Attachment A - Roads and Maritime Design Review (Revision 2)

Transport Roads & Maritime Services Engineering Services Road		Project Title Proposed Signalised intersection- Catherine McAuley Catholic College – 507 Medowie Rd and South St – Medowie		Design Organisation MPC		Drawing No. 17-928		ROAD ENGINEERING This design review by the Roads & Maritime Services (hereafter referred to as "RMS") covers an examination of the provided drawings and report to determine if they conform to RMS policy and practice. The review is not a proof check or a dimensional check and may not be complete.	
Review requested by: 01 – Kylie-Anne Pont, Development Assessment Officer, RMS Hunter 02 – Kylie-Anne Pont, Development Assessment Officer, RMS Hunter		Review performed by: 01 – Greg Pollard (GP), Designer, Design Newcastle, Engineering Services, RMS 02 – Greg Pollard (GP), Designer, Design Newcastle, Engineering Services, RMS		Project Status 1 – Strategic 2 – Strategic		Issue No 01 – 02 –		Review Issue Date 01 – 11/4/18 02 – 16/08/18

Statement by reviewer: 01 – Review of 8 Plans dated 23.03.18 rev 1 – Proposed Signalised intersection- Catherine McAuley Catholic College – 507 Medowie Rd and South St.

Engineering Plans

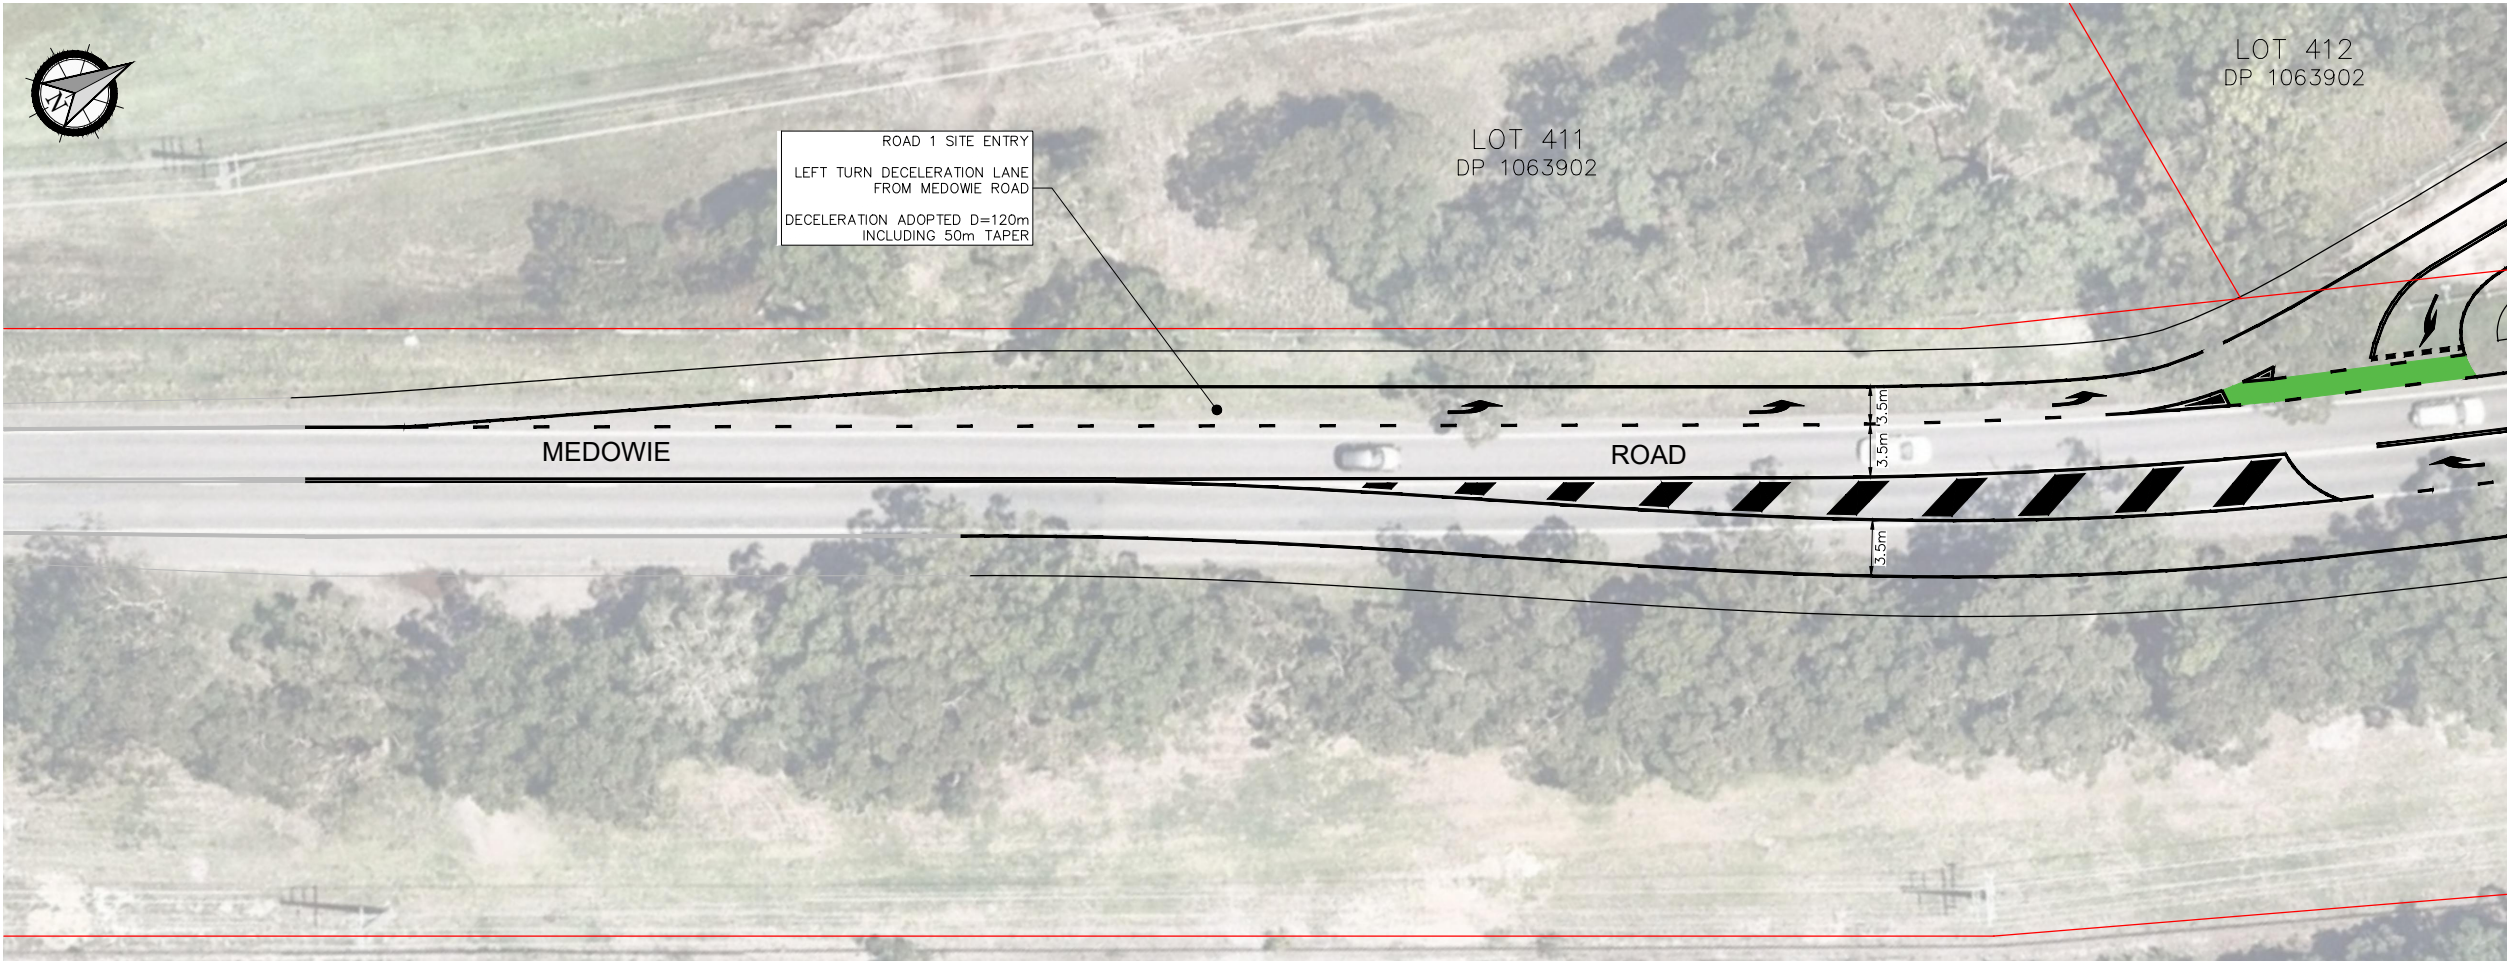
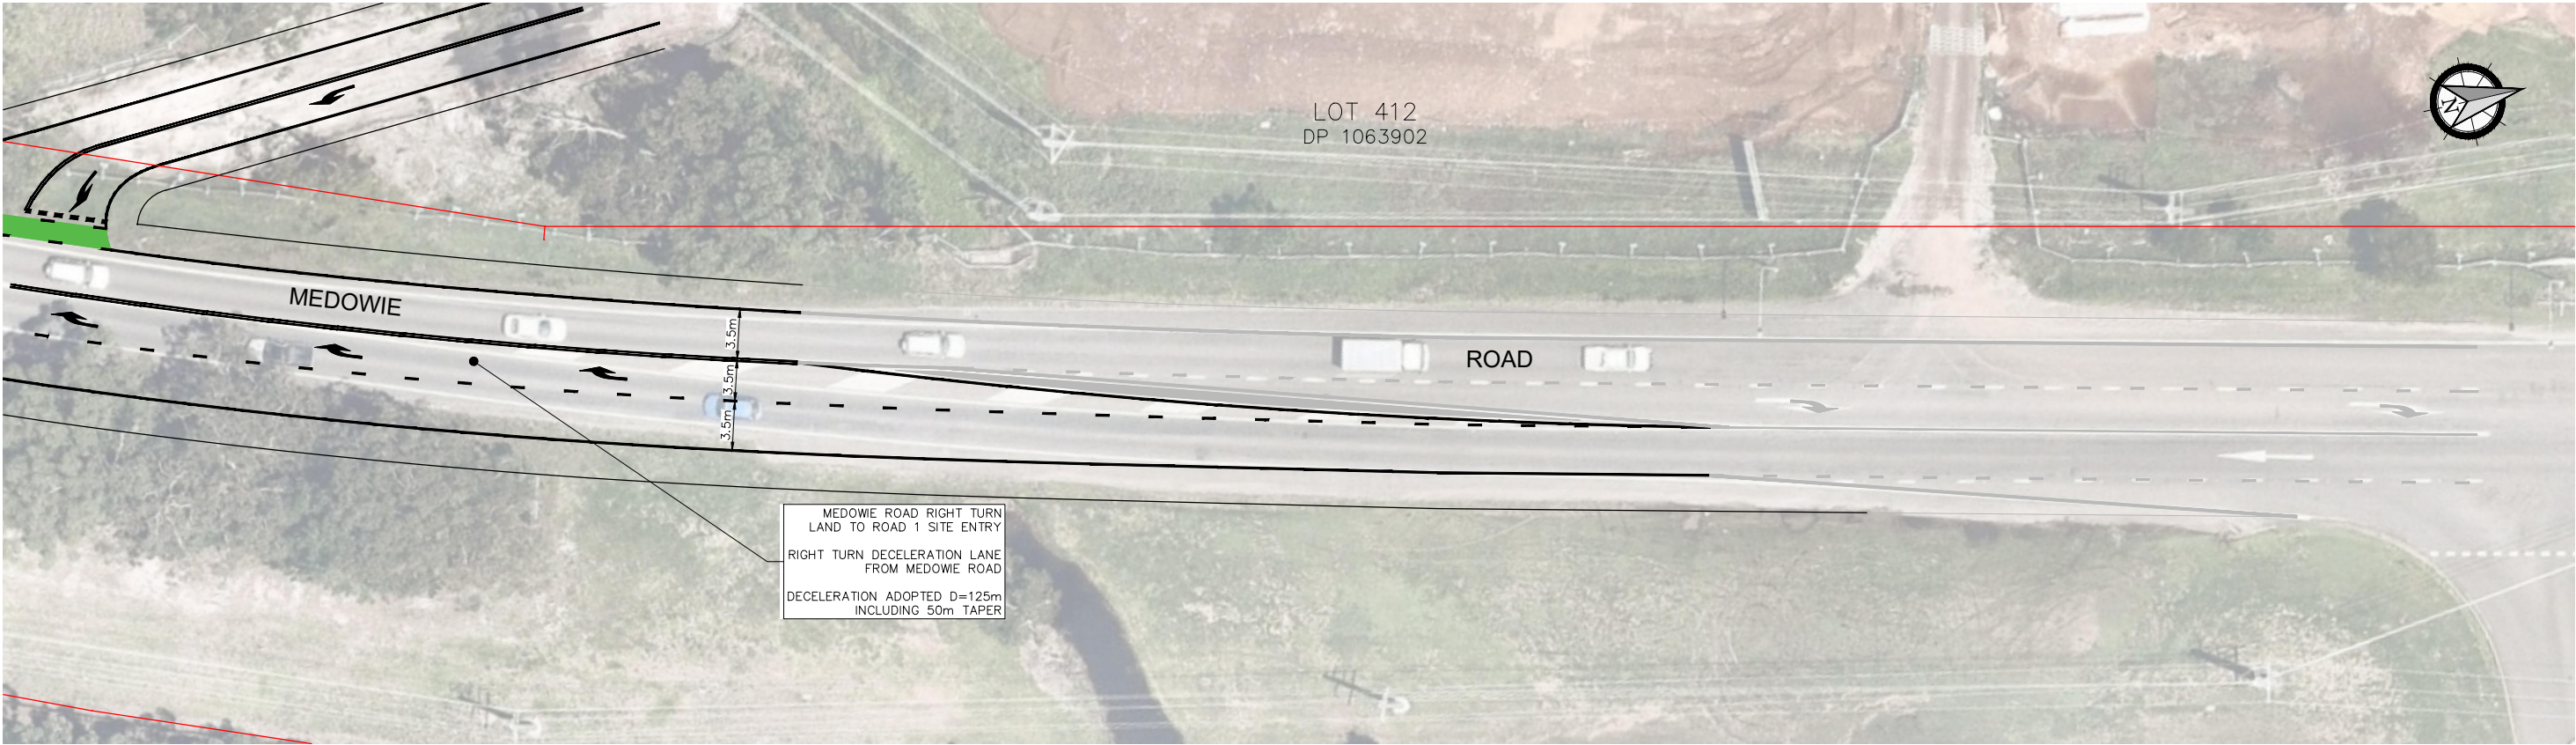
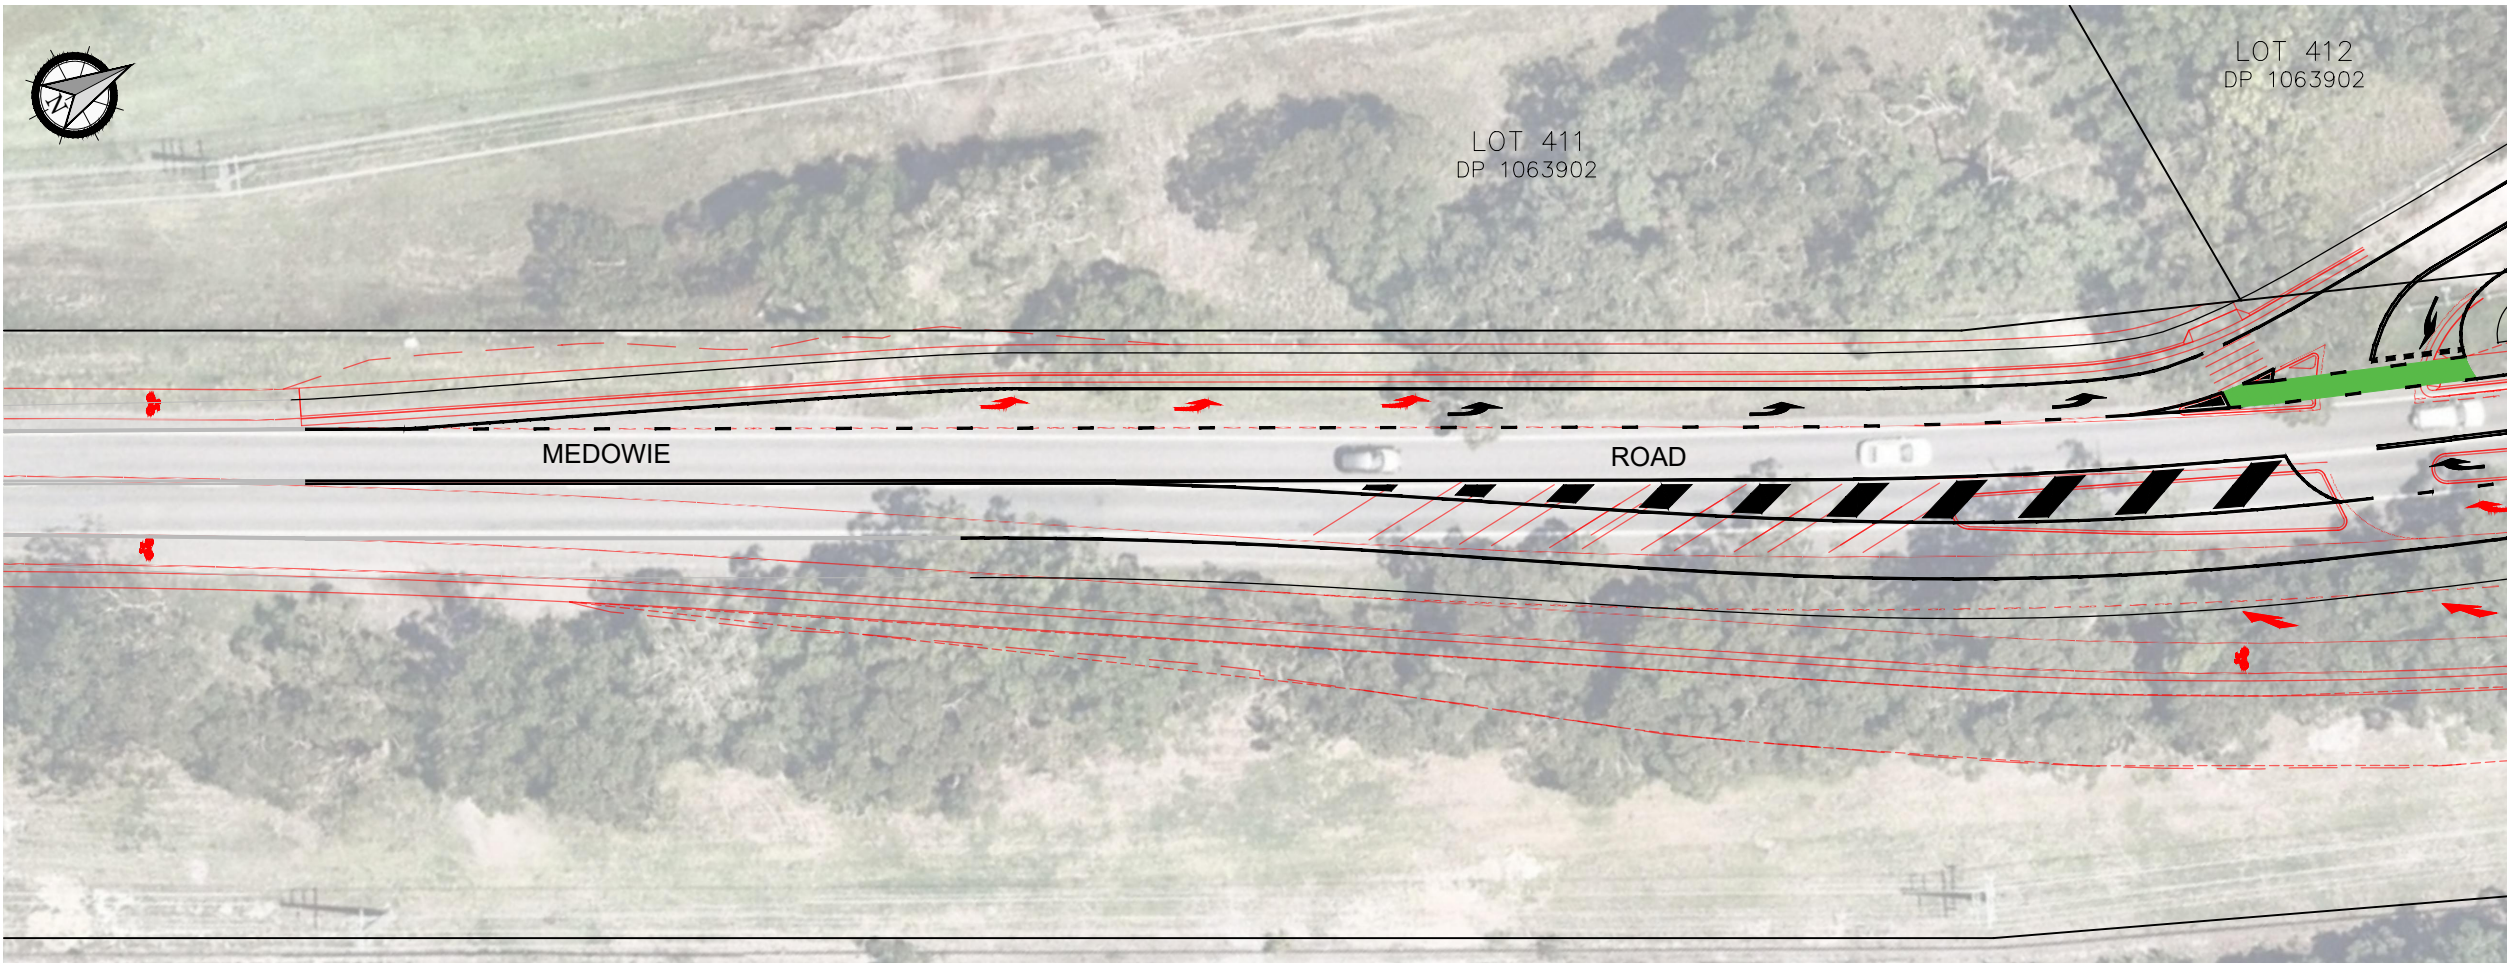
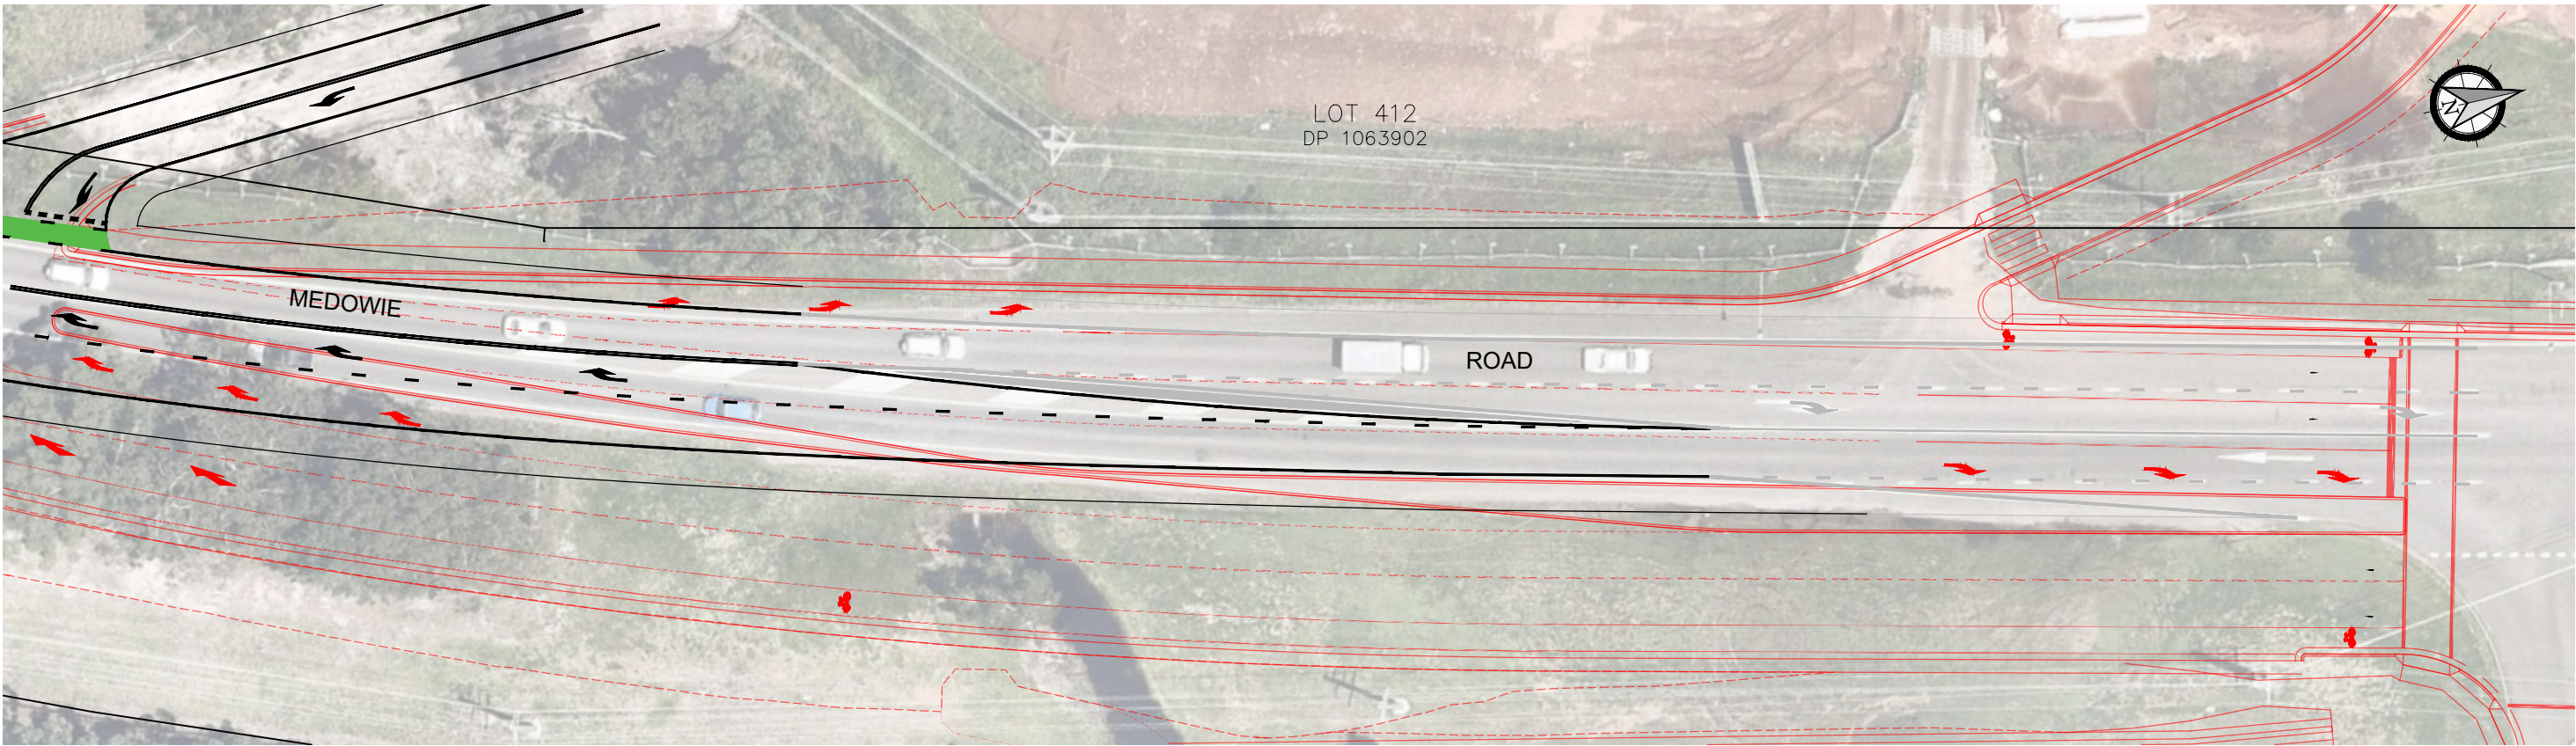
2.	11/4/18	GP	D	Right turn Deceleration lane into Road 1	R02, R03	The Right Deceleration Lane should be marked to allow for comfortable deceleration to stop. Refer Austroads Part 4a table 5.2. The internal road network should be based on 10km/hr shared zone. GP 16/08/18 Right turn lane shown is substandard for design speed and posted speed.	Road has been re-aligned to enable this to be achieved	Engineer- MS	19/11/2018	O

3.	11/4/18	GP	D	Left turn Deceleration lanes	R02, R03, R04	The Left Deceleration Lanes should be marked to allow for comfortable deceleration to 20km/hr. Refer Austroads Part 4a table 5.2. The internal road network should be based on 10km/hr shared zone. GP 16/08/18 left turn lane shown is substandard for design speed and posted speed	As part of the re alignment of the road this has been incorporated on the latest plans	Engineer- MS	19/11/2018	O

4.	11/4/18	GP	D	Intersection opposing right turns	R02, R04	Please show turn paths on design set. Need to provide back to back right turns for Single unit trucks at intersection with 1m path offsets refer Austroads part 4.A.16.2 GP 16/08/18 vehicle turn paths not shown.	Not required due to phasing of signals. Refer to attached phasing diagram from SECA Solutions SIDRA modelling	Engineer- MS	19/11/2018	O

5.	11/4/18	GP	D	On road Cyclists location	R02, R03, R04, R05	On road cyclist location should be marked out at back of shoulder on left deceleration lanes at Posted speed of 80km/hr GP 16/08/18 onroad cyclist shown in incorrect location for design speed	Cycle lane is now located at the back of the left shoulder and deceleration lanes. Refuge island between right turn into the school has been provided	Engineer- MS	19/11/2018	O

6.	11/4/18	GP	D	Acceleration to Merge lanes	R02	Merge length for Acceleration lanes are short they should be 90m for 90km/hr Refer Austroads 4a table 5.5. Minimum desirable length 190m. GP 16/08/18 Southbound and Northbound acceleration lanes are substandard for design and posted speed.	This has been amended on the latest plans	Engineer- MS	19/11/2018	O

7.	11/4/18	GP	D	Left turn Deceleration lane to South St	R02, R05	Deceleration Lanes should be marked to allow for comfortable deceleration to stop. Refer Austroads Part 4a table 5.2 and adjusted for the down grade GP 16/08/18 left turn lane shown is substandard for design speed and posted speed	This has been amended on the latest plans	Engineer- MS	19/11/2018	O

8.	11/4/18	GP	D	Pedestrian crossing	R02, R04	Pedestrian crossing lines may be required on all legs of the TCS. Standard RMS Policy.	This has been amended on the latest plans	Engineer- MS	19/11/2018	I	GP 16/08/18

9.	11/4/18	GP	D	Shared path on South Street	R02, R04	Shared path on South Street should be considered for Children riding to school.	This is in discussions with PSC with defining the extent of path and responsibility.	Engineer- MS	19/11/2018	O

11.	11/4/18	GP	D	Bus stop location	R02, R04	Bus stop needs to be located outside the road reserve GP 16/08/18 deceleration lane to bus zone only adequate for posted 40k zone	Bus stop is located outside the RR. Bus deceleration lane has been increased to suit the road design speed.	Engineer - MS	19/11/2018	O

16.	11/4/18	GP	D	Southbound approach to Signals	R02, R05	The lining needs to be seen from north side of the crest at the design speed to indicate the presence of the intersection and possible long queues	To be resolved during RMS design approvals process.	Architect - TH	19/11/2018	O

18.	11/4/18	GP	D	South St Deceleration lane	R02, R04, R05	South St is posted as 60km/hr Therefore deceleration lane length should be 75m. - Austroads 4a Table 5.2	No increase in traffic volume is proposed from South Street and this intersection has been previously approved by PSC based on a 'full' development within Pacific Dunes.	Engineer - MS	(DD/MM/YY)	O	Council closeout
